Our ref: HMS ID 1309

Sandstone Precinct – Lands Building – SSD 7484 Modification 17 - Lands Building Design Refinements (SSD-7484- Mod-17)

The drawings and documentation for the SSD Modification 17 have been reviewed. As delegate of the Heritage Council of NSW, I provide the following comments:

DRAWING NUMBER **SP-DA-G-3250** ISSUE **01**

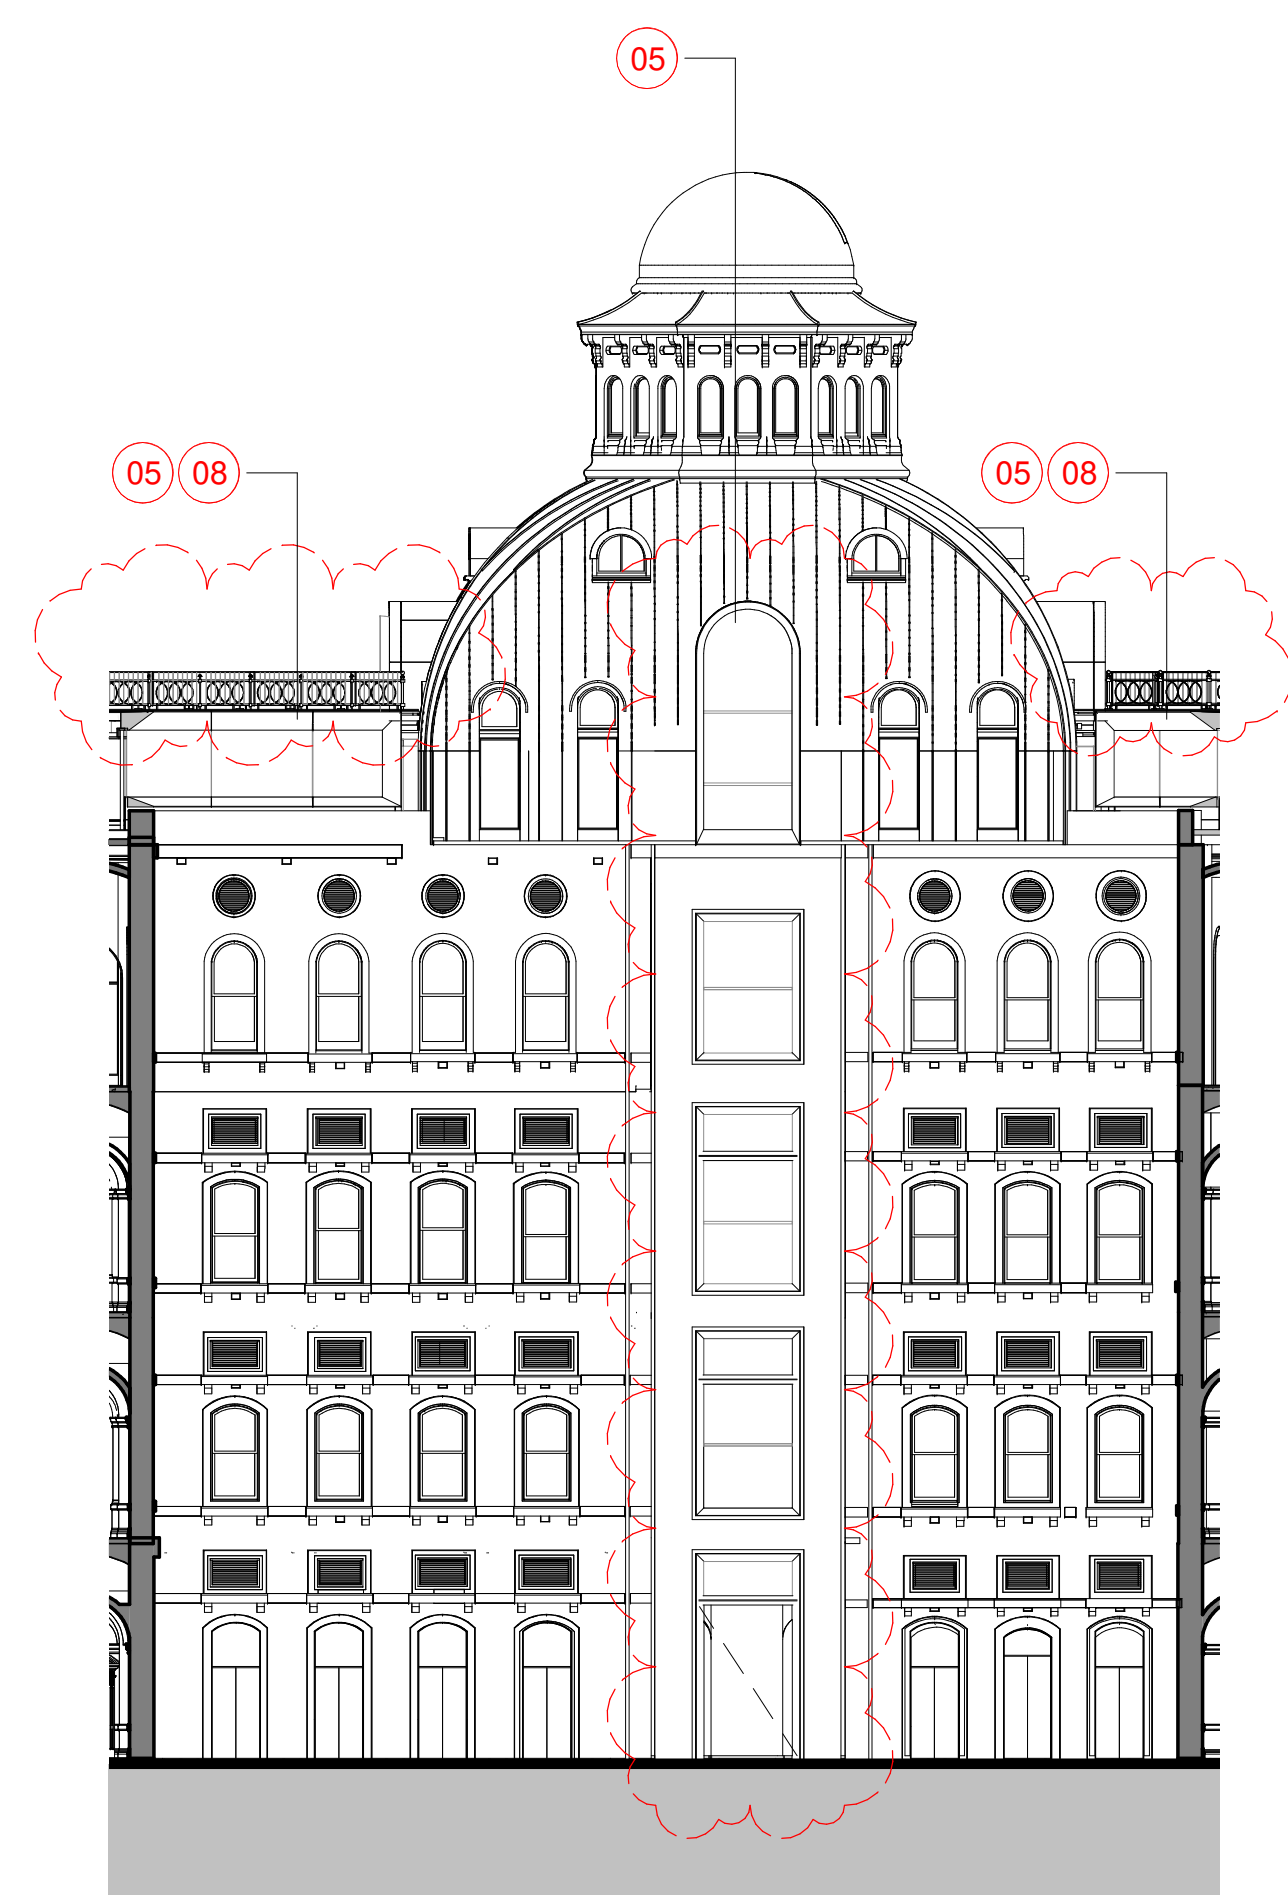
- The proposed changes to the facade detail of the north courtyard as endorsed by the Design Review Panel is noted in the Heritage Statement as reducing the amount of original fabric to be removed and therefore a good heritage outcome. It is noted the new design better complements the pattern of horizontal and vertical architectural lines in the façade and does not visually dominate or detract from the original elements. This is particularly applicable to the window within the dome. This design change is supported.
